8th May 2019

YOUR REF: R/72/19/PL
Case Officer : Mrs A Gardner

Demolition of existing garage & store on existing dwelling & construction of 2 new dwellings in rear garden 6 Manor Road Rustington by applicant U2 Developments Ltd

DRAWING No: DS/6MANOR/03 rev 1

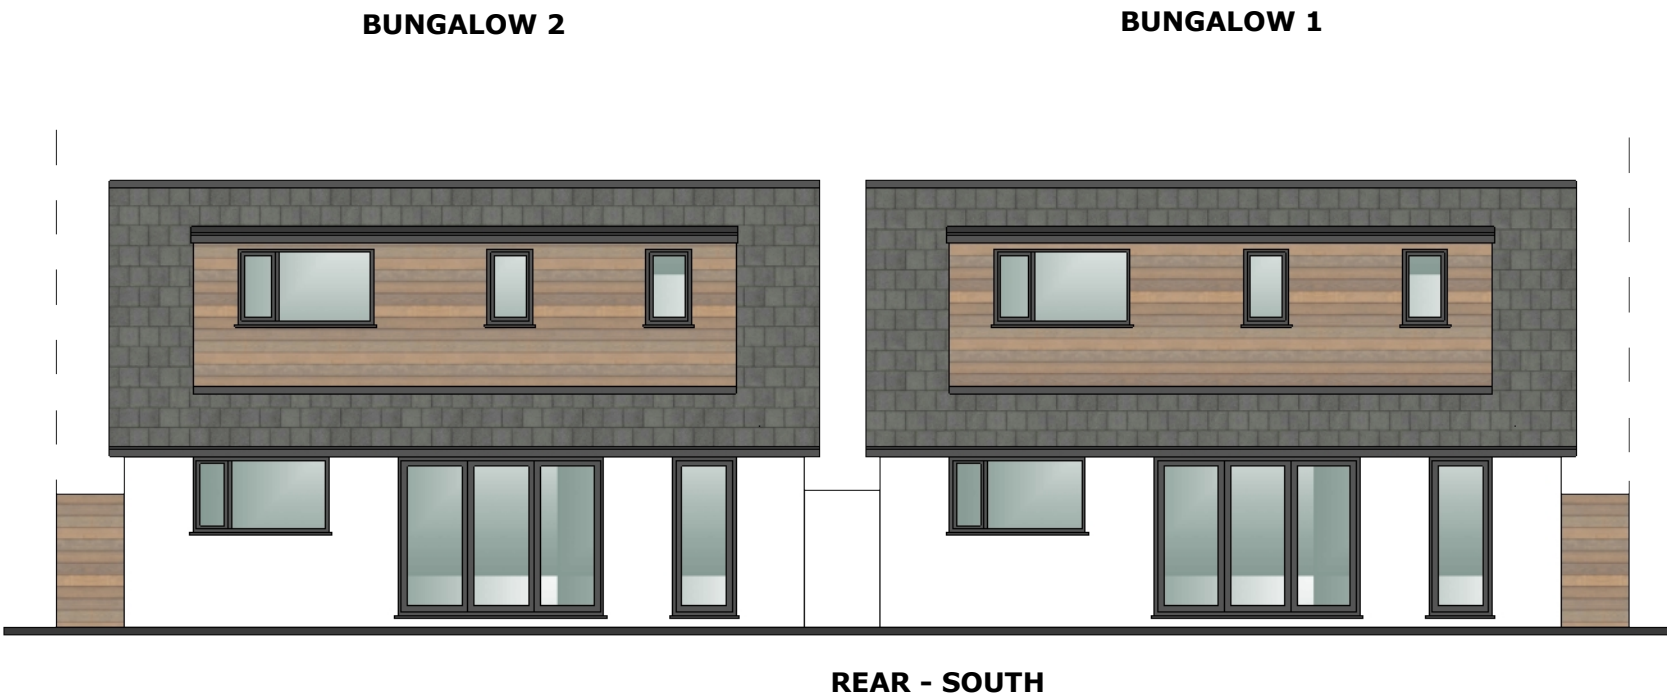
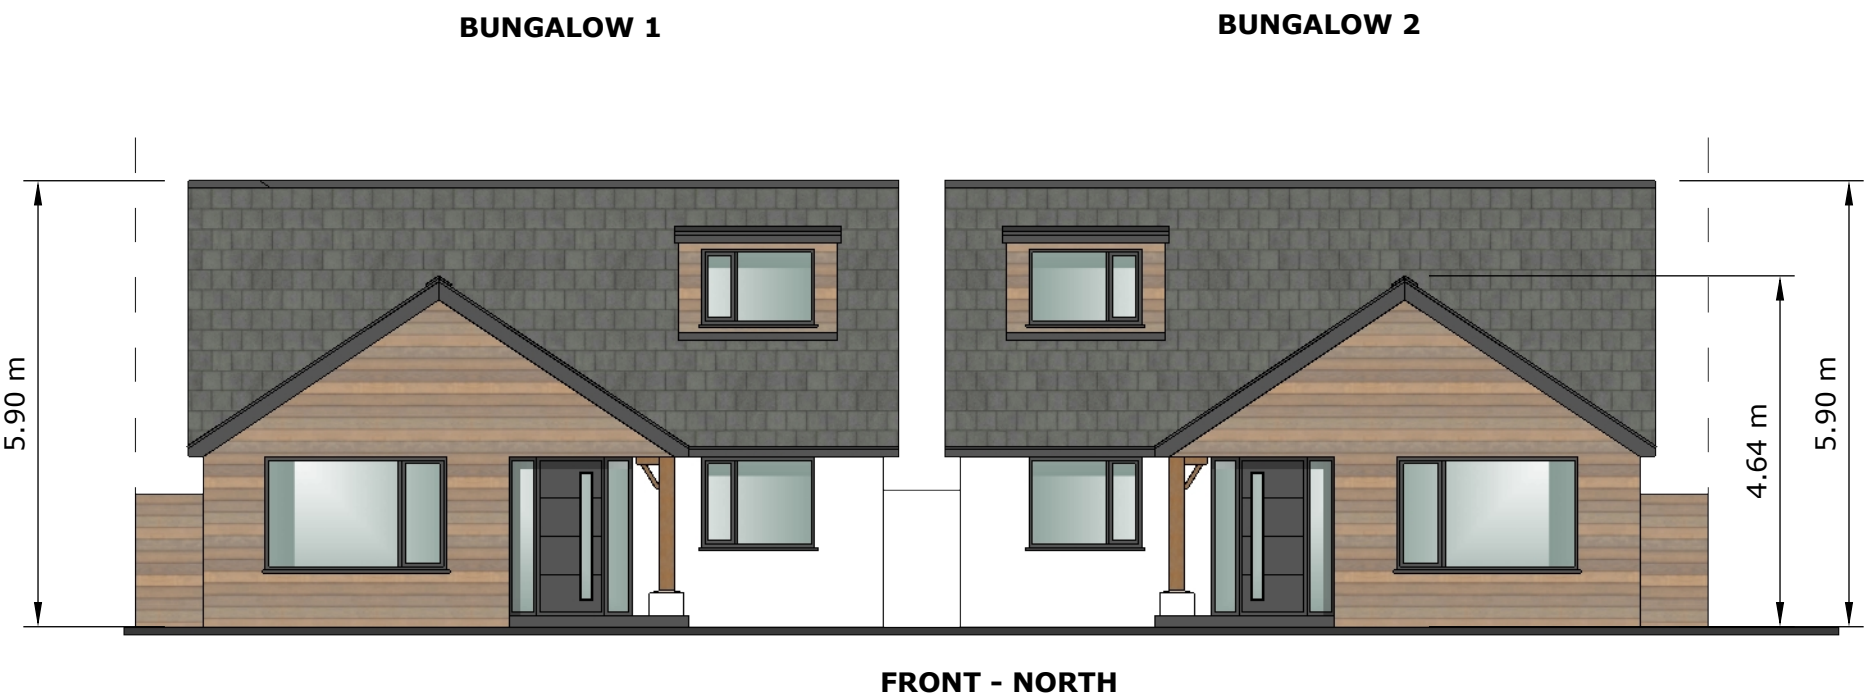
On the plans/drawings proposed there are discrepancies with regards to the heights of the roof of the properties which both seem very excessive and not in keeping with the other bungalows in the area, the design too, not in keeping.

This is also going spoil the view from our garden and that of our neighbours either side. The drawings show the side view/elevation with a side window, and another one with none? which is it? of course we would not want any windows to overlook our garden as it would be an invasion of privacy.
